**RE: BP#2017-00268 105 Sherman Street - Plan review**

Subject: BP#2017-00268 105 Sherman Street - Plan review

1. Provide layout of existing stairs and landing with dimensions. ( I understand that these have been removed but I will need approximate dimensions).
2. Provide layout of proposed stairs (on separate plans) with complete dimensions of both landings, width of stair, exact location and dimensions of bay window, and clarify the width of the stairs where the stairs meet the bay window.
3. Provide frost protection as required. The existing footprint is smaller than the proposed footprint. Clearly show frost protection as required.
4. Provide opening limitations of the guardrail.

# HANDRAIL AND LEDGER BOARD DETAILS

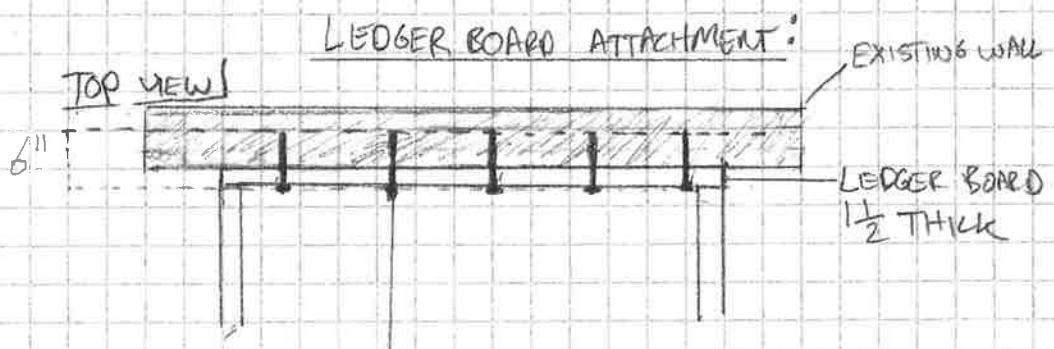
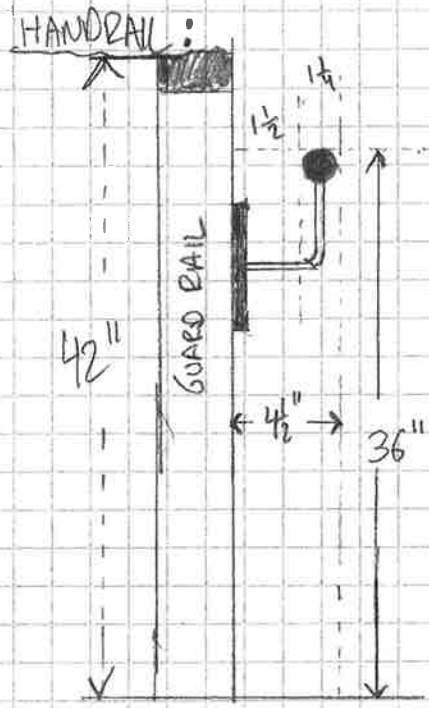
5. Provide attachment detail of the proposed stairs and landings to the existing structure.
